Item No. **Report of the Head of Planning, Transportation and Regeneration**

Address LAND ADJOINING 1/3 BOTWELL CRESCENT HAYES

Development: Erection of a two storey building to create 2 x 2-bed self-contained flats with associated parking

LBH Ref Nos: **72105/APP/2018/3989**

DRAWING
Proposed Floor Plans
& Schedule of Unit Areas

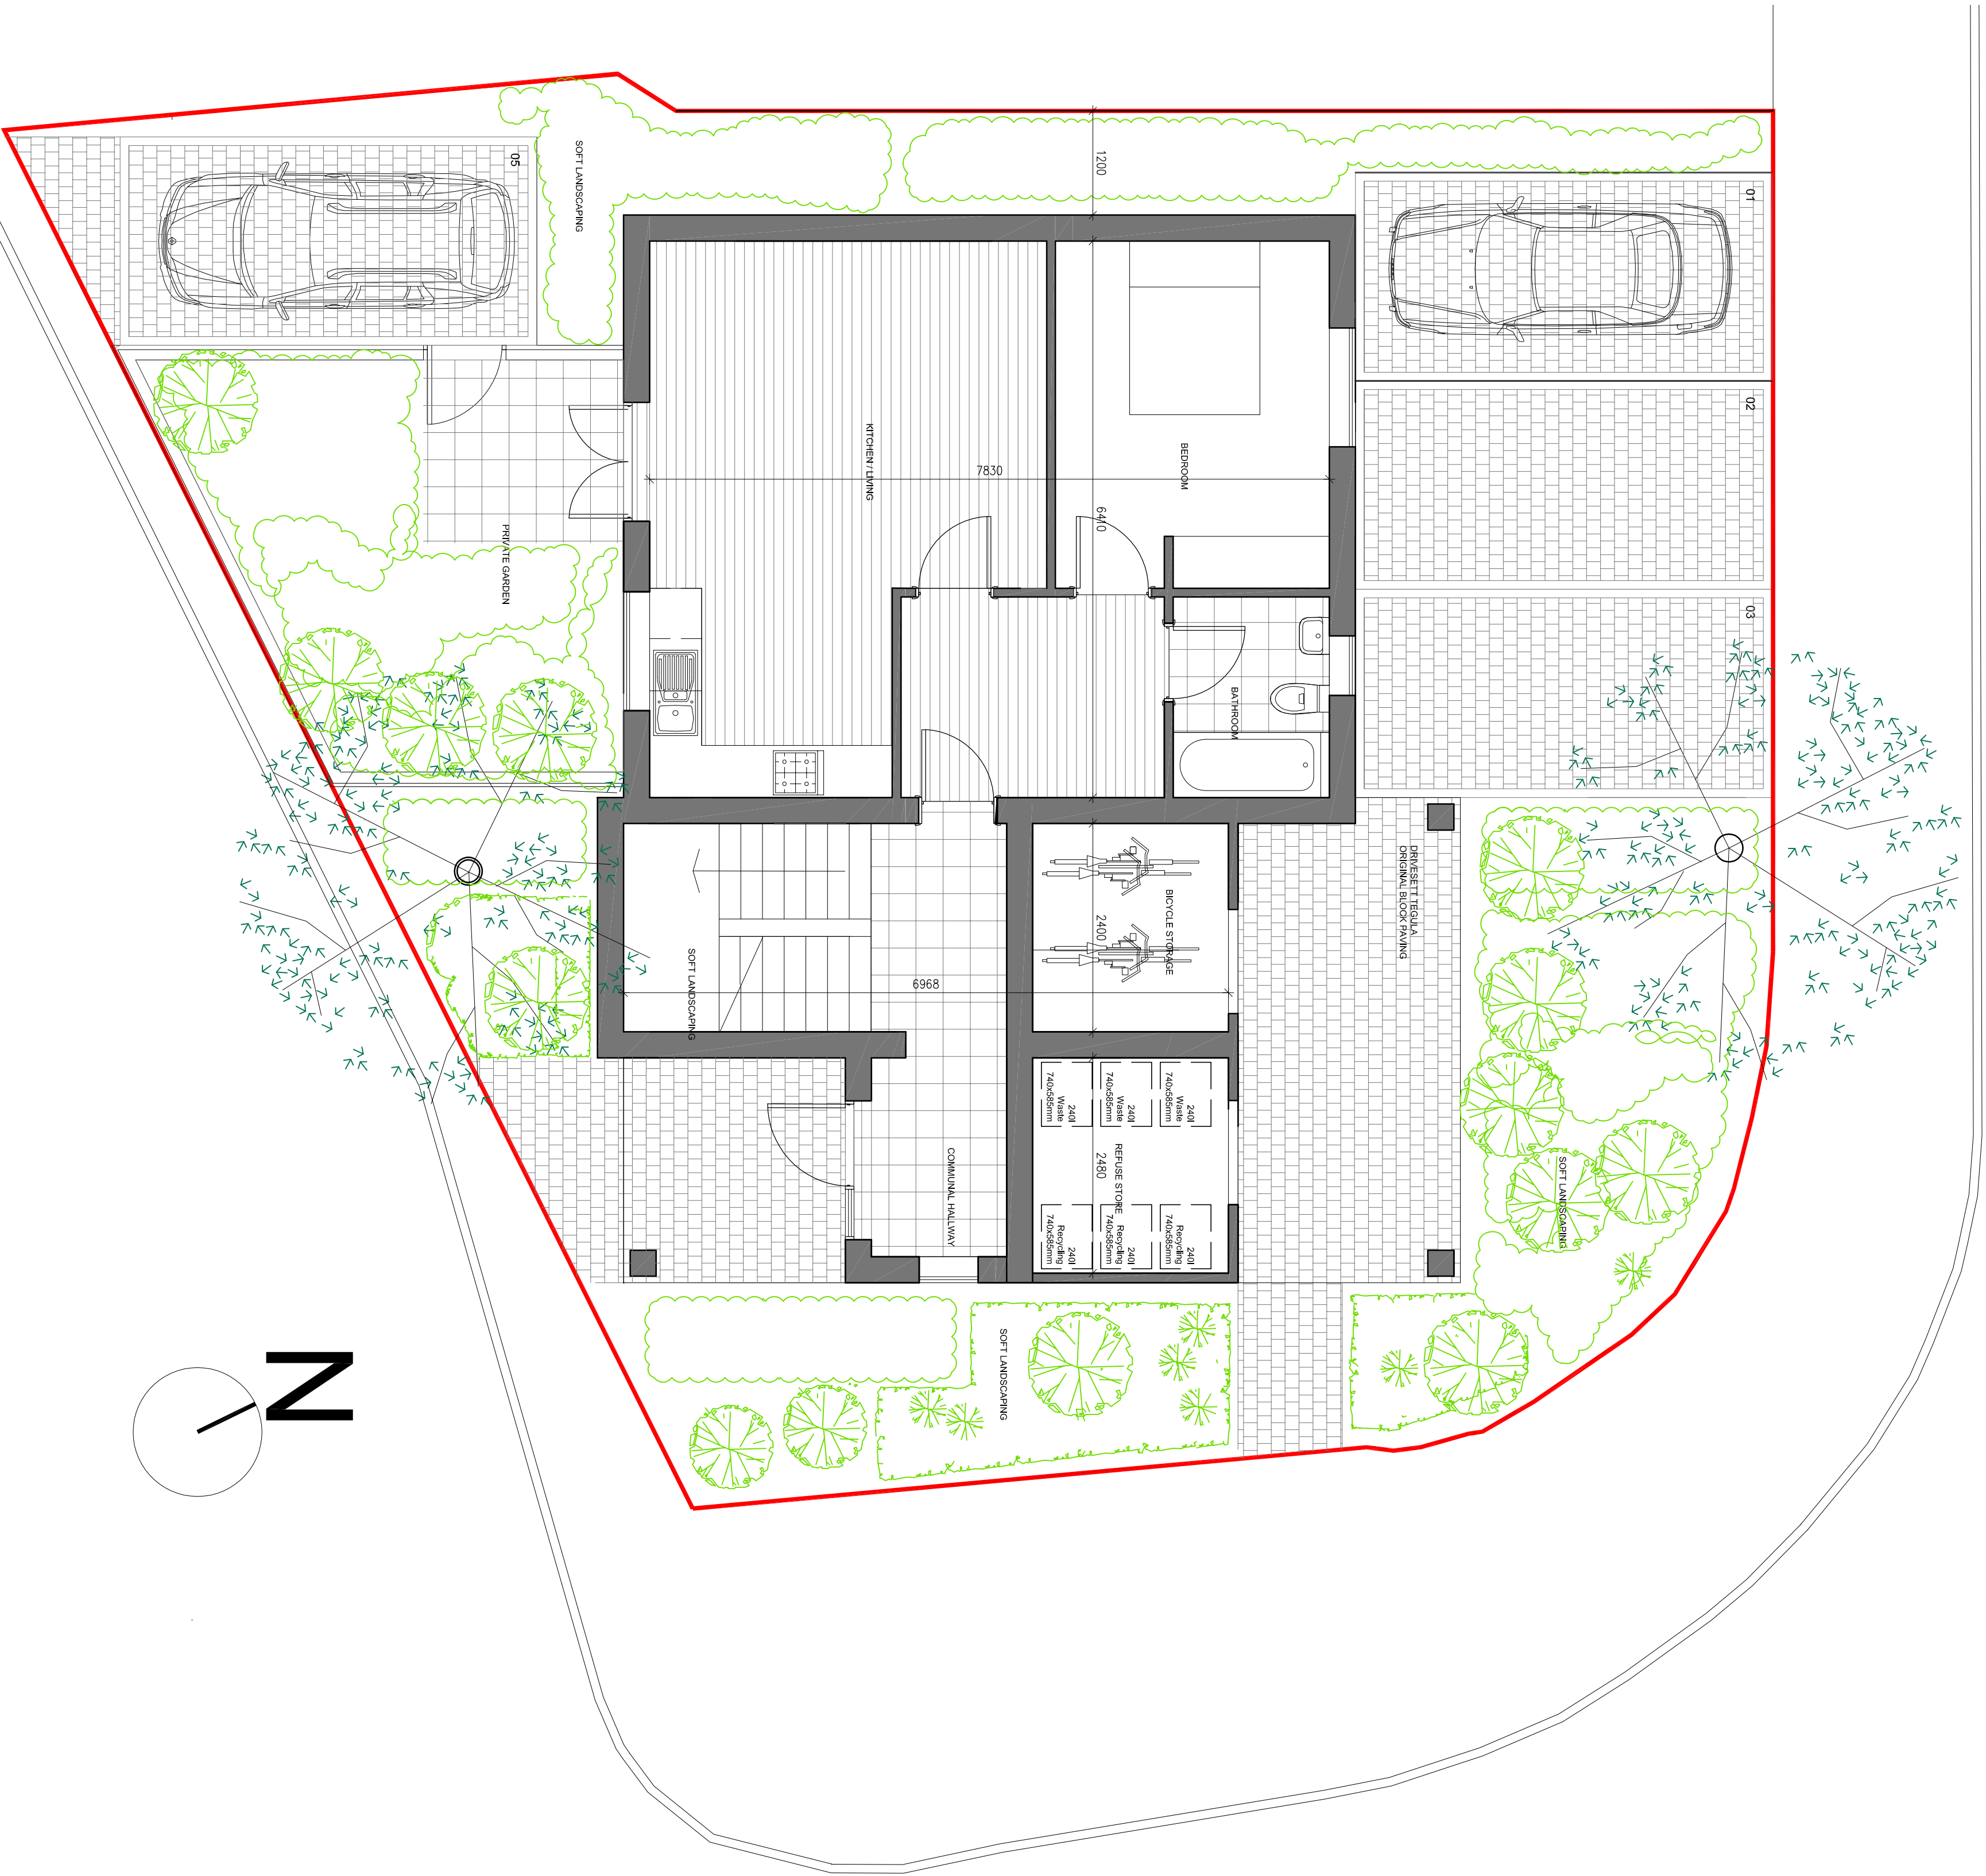
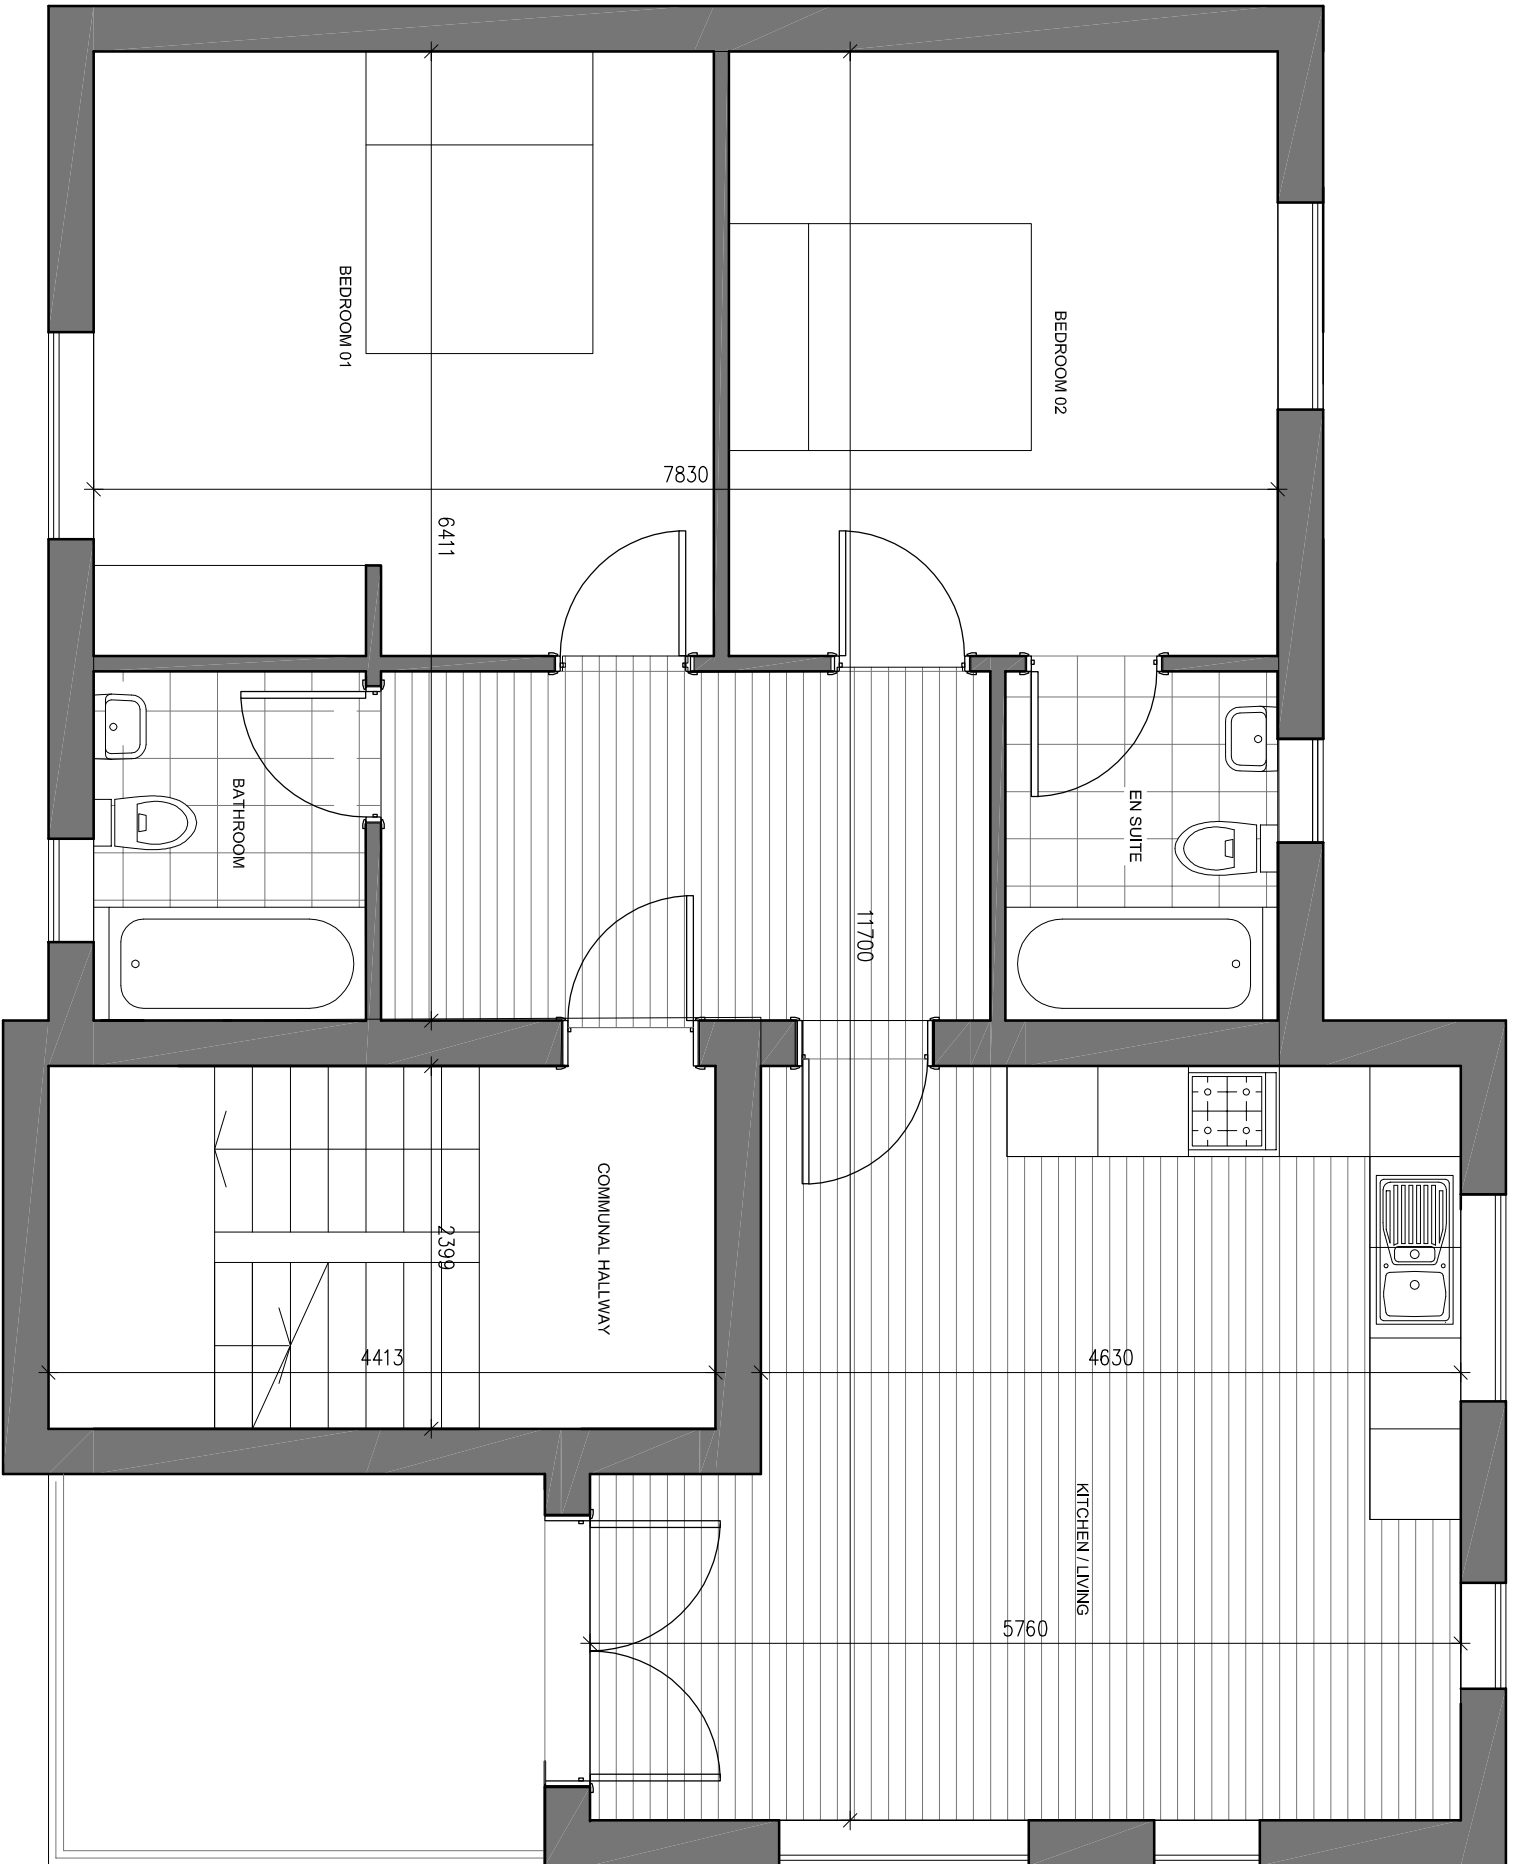
Whilst the submitted plans depict the required provision being accommodated for within the site curtilage, when considering the location of the proposed access, specifically the easternmost parking bay and its proximity with the Botwell Lane/Botwell Crescent junction, concerns are raised with the site frontage not being able to afford a sufficient linear distance beyond the bellmouth's tangent point in order to host a suitable private vehicular access.

The proposals are therefore expected to result in vehicles having to reverse into and out of the site generating conflicting vehicle movements at the junction. Mindful of the above, refusal is recommended.

The proposed 2 storey building will be 1.2 metres from the flank elevation of flats fronting Botwell Crescent, with the closest being Flats Nos 1 and 3. The existing flats are separated from the application site by a side passage. There are a number of ground and first floor windows and a door within the existing development facing in a South Eastward direction and at right angles towards the application site. This matter was discussed with the applicant with regard to previous applications and it is confirmed that none of these serve habitable rooms. The proposal includes no first floor side facing windows and only high level windows are ground floor.
